DECISION DELEGATED TO HEAD OF PLANNING

Application No: H09-0339-26 **Applicant:** Lotus Sun Property Ltd

Proposal: Change of use from an MOT testing station, vehicle repair garage and petrol filling station to a flexible (Class Sui generis) commercial unit, while retaining the petrol filling station use

Location: 36 West End Holbeach Spalding

Proposed front elevation

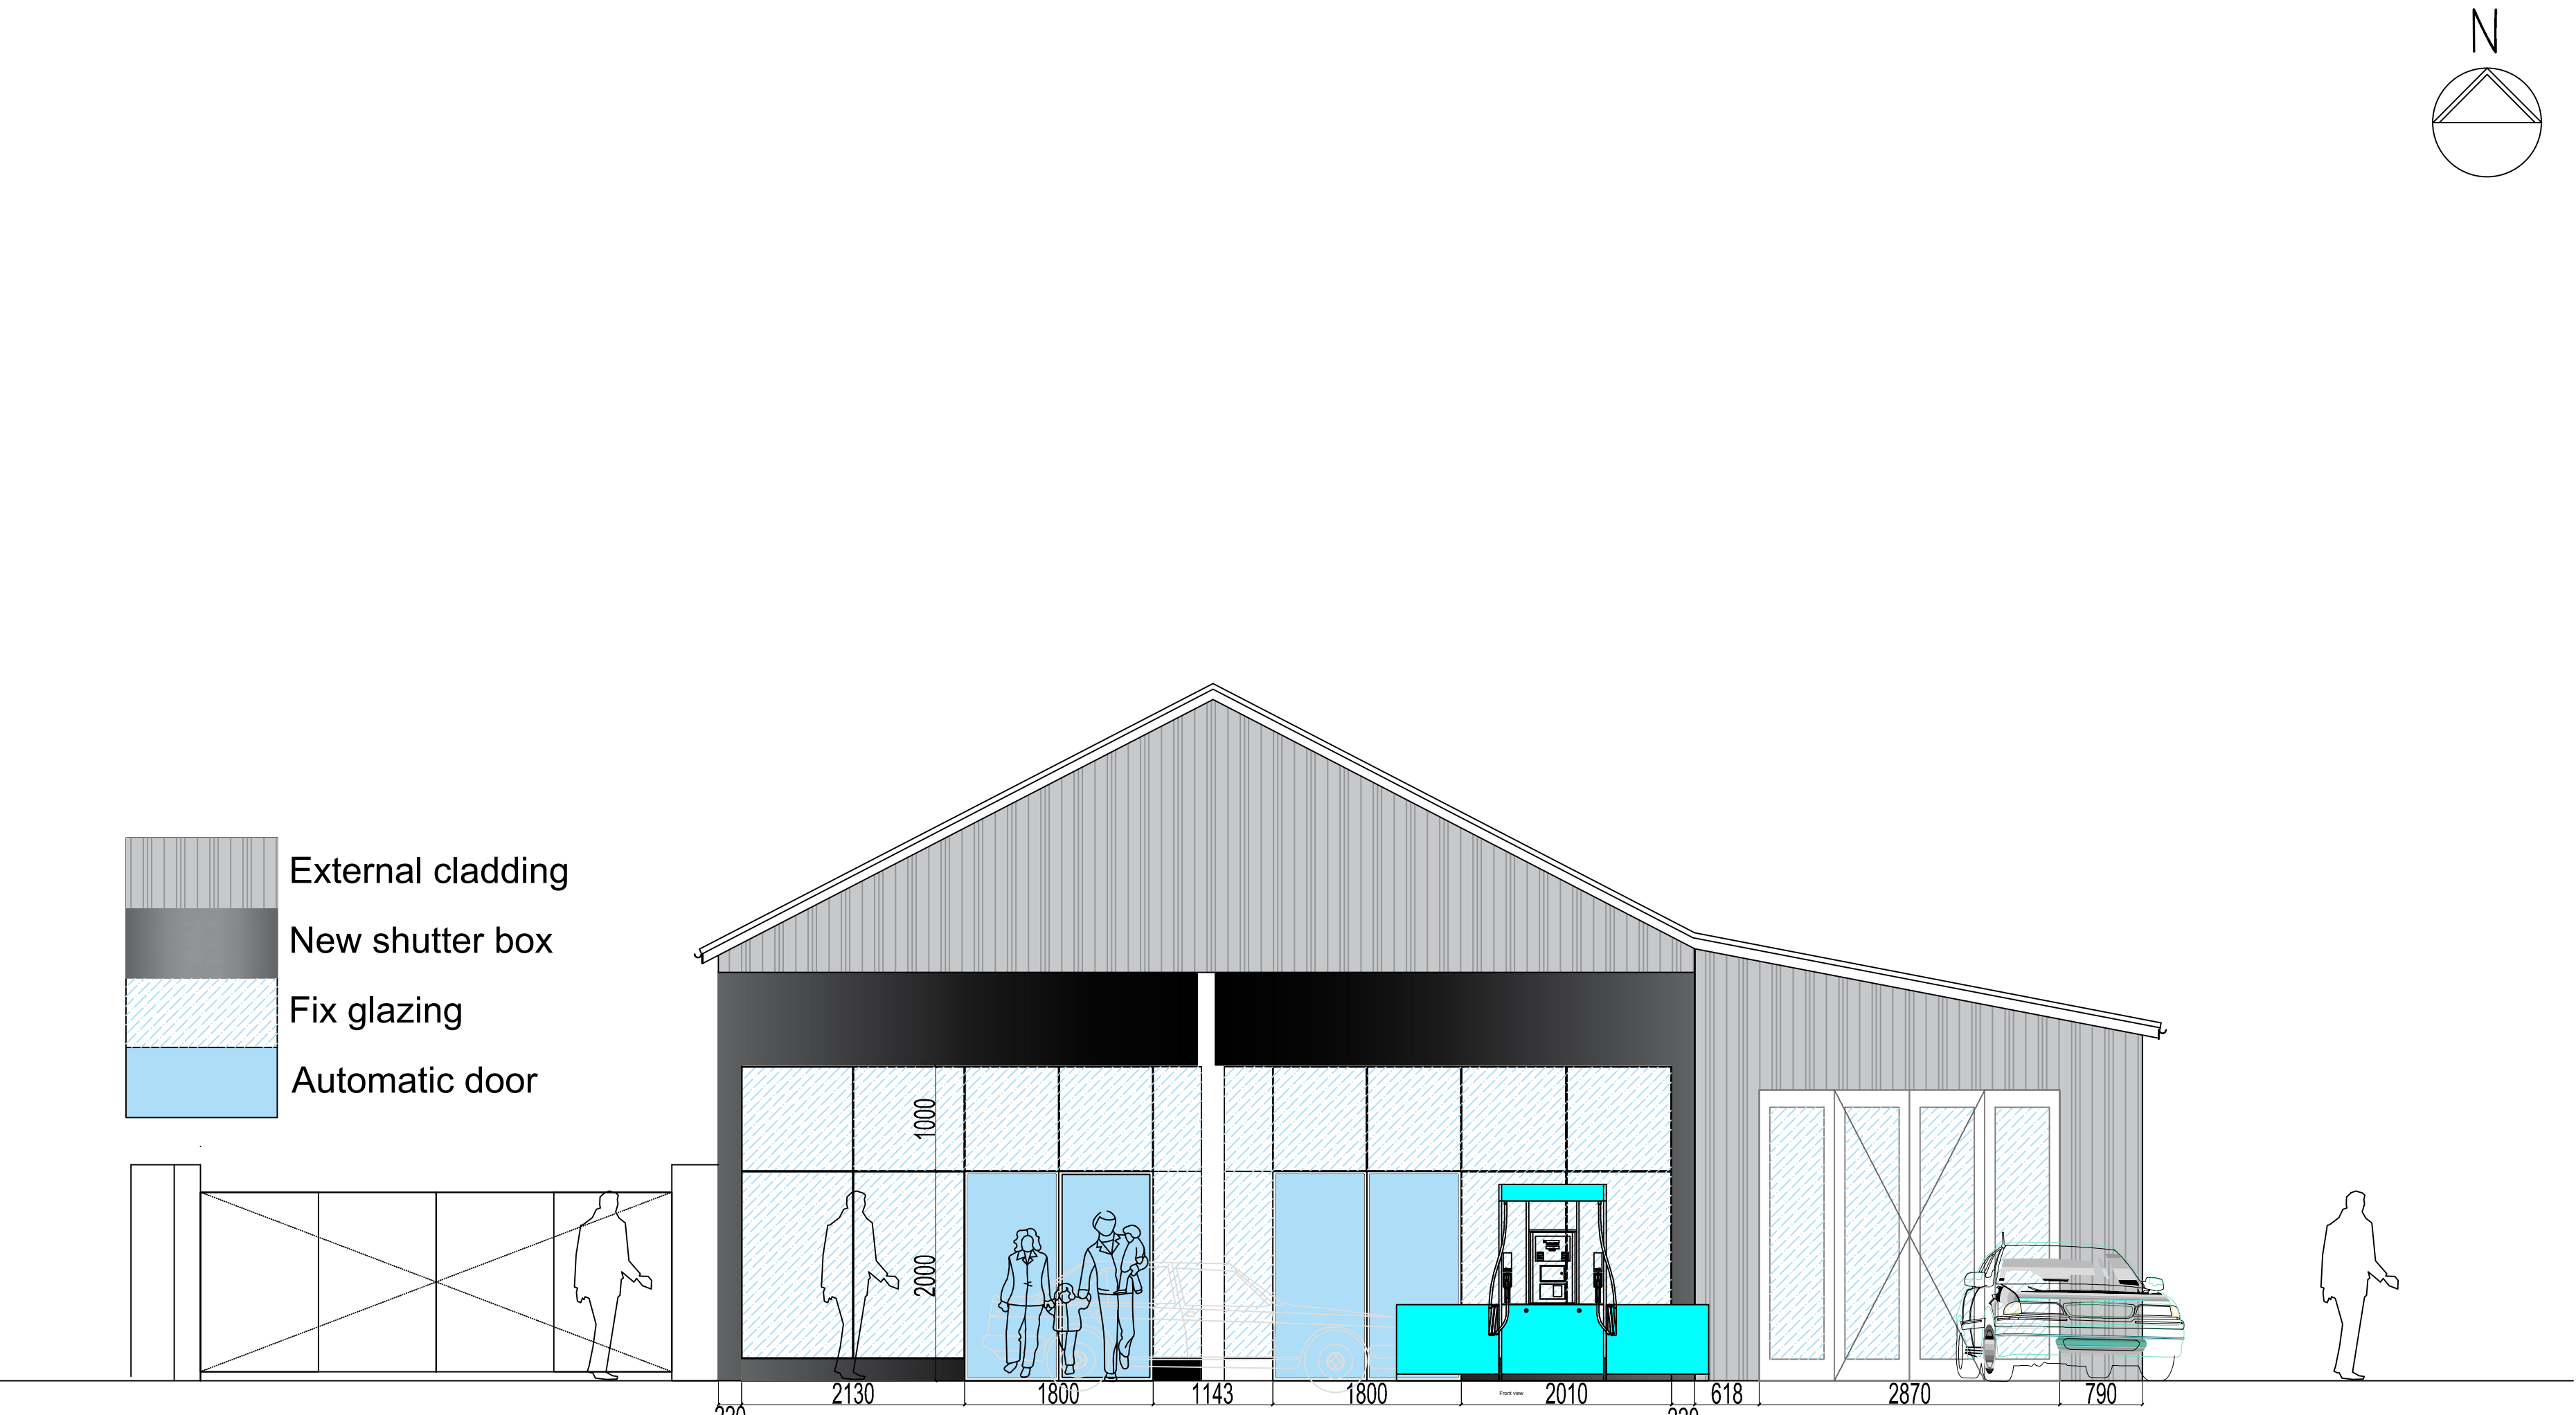
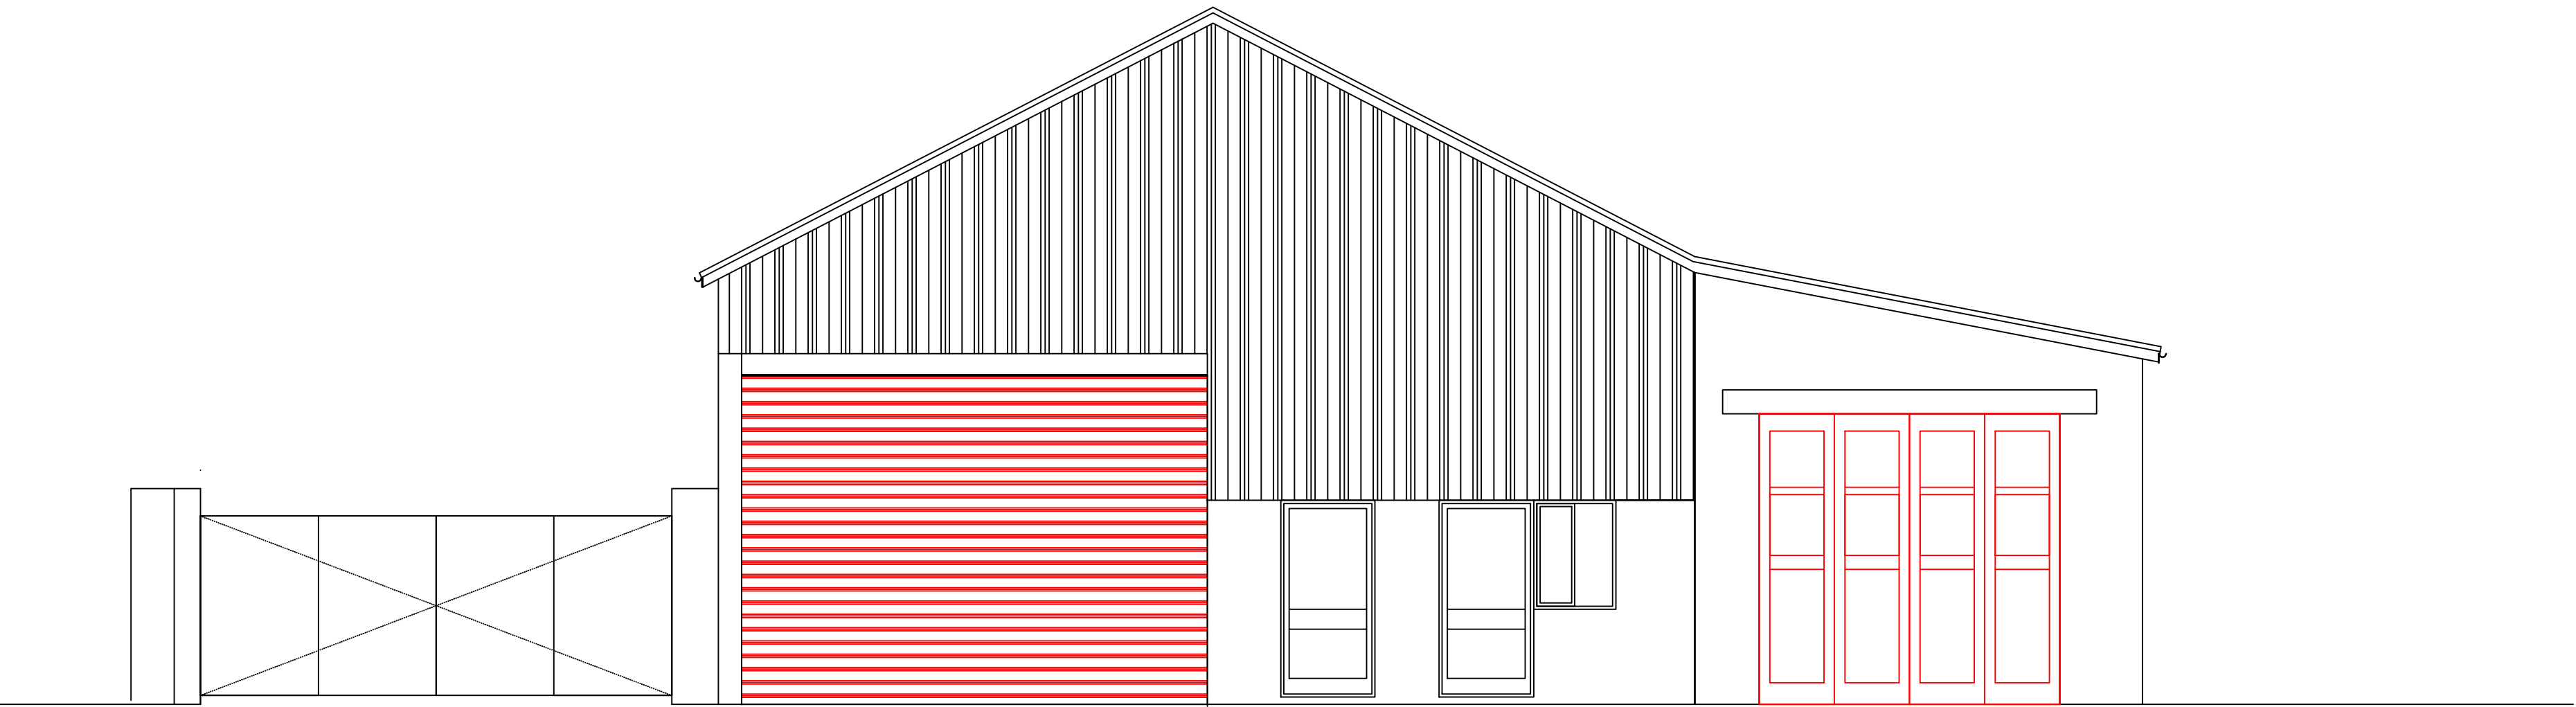
The application contains several aspects which would not typically be acceptable in a conservation area setting (i.e. grey external cladding, box shutters etc) however, a site assessment shows that there is additional context which mitigates against these arguably harmful aspects. Namely, the site as extant is itself an eyesore, and whilst it is proposed to retain the relatively functional looking building, in a poor state of repair and is therefore considered an eyesore in the immediate area. As a result, the proposed works, which would result in a modernised and tidied appearance would represent a neutral, possibly even positive effect upon the CA, even though the proposal contains aspects which, in typical circumstances, would not be considered appropriate. In this instance, the proposal can be considered to assist in conserving and/or enhancing the historic environment.

However, having said that, should you be minded to approve the application, I would recommend imposing a condition that requires the submission of the details of the proposed box shutters. This is because an overly prominent box shutter would appear out of sorts and incongruous. The applicant should be minded that any shutter storage should be as discreet and low profile as possible.

The Conversation Officer has been consulted on this application who stated that the alterations proposed would not typically be acceptable in a conservation area setting. However, given the unattractive look of the existing building, it is considered that the alterations would result in a modernised and tidied appearance and would represent a neutral, and possibly even positive effect upon the Conservation Area, even though the proposal contains aspects which, in typical circumstances, would not be considered appropriate. In this instance, the proposal can be considered to assist in conserving and/or enhancing the historic environment.

LOCATION PLAN
SCALE 1:200

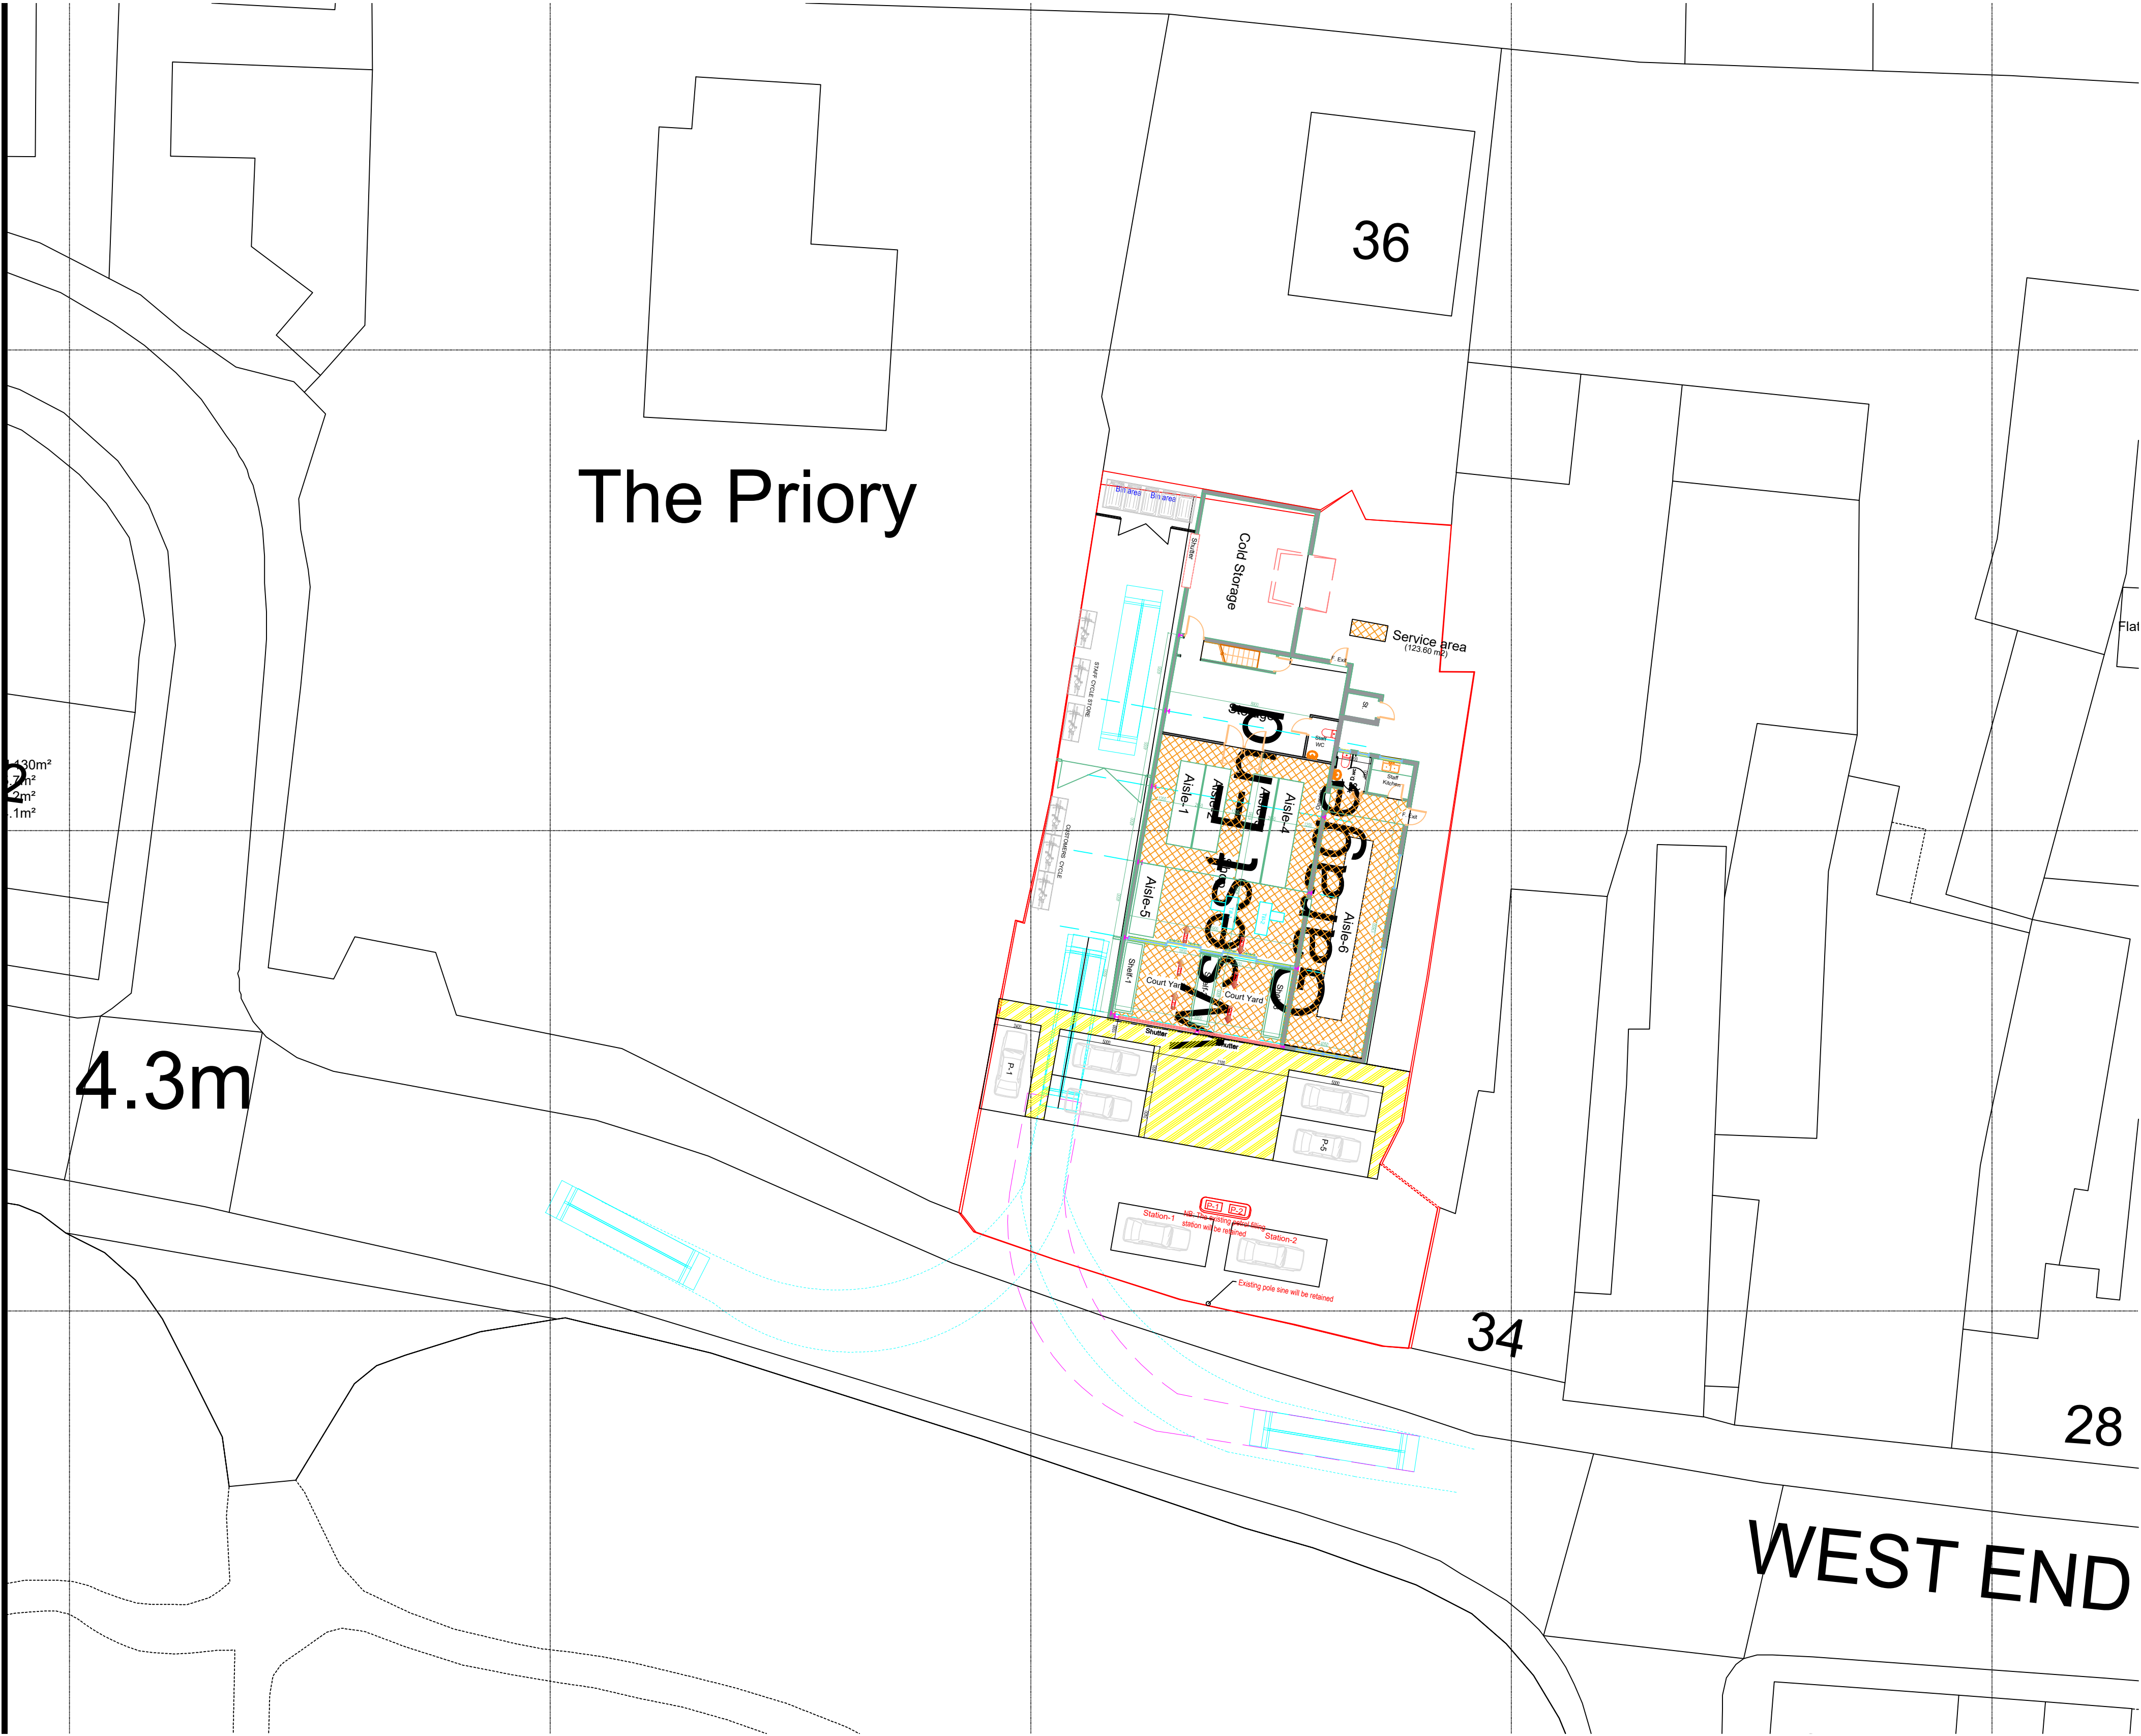
Deferral: LCC is not currently in a position to support the application and requests further assessment, supporting evidence, revisions and/or dialogue, as set out in the response. **ADDITIONAL INFORMATION REQUIRED** Parking justification is required - 4 spaces for retail, cafe, office, services use is low. For food retail we'd expect to see 1 space per 14m² of gfa.

Change of use from an MOT testing station, vehicle repair garage and petrol filling station to a flexible (Class Sui generis) commercial unit, while retaining the petrol filling station use. The proposal relates to the change of use of part of the existing building to form a convenience store with a gross floor area of approximately 124 m². Deliveries will be limited to approximately two deliveries per week from the wholesale supplier, Booker. The servicing demonstrated is acceptable, and parking (option 5) is acceptable. Visitors to the shop will either be already on the site using the Petrol pumps or call in the shop for convenience. Either way they will be quick visits of no more than 10 minutes at a time. It is a Village location with only 2 petrol pumps on site the change of use will not create an unacceptable impact on the public highway.
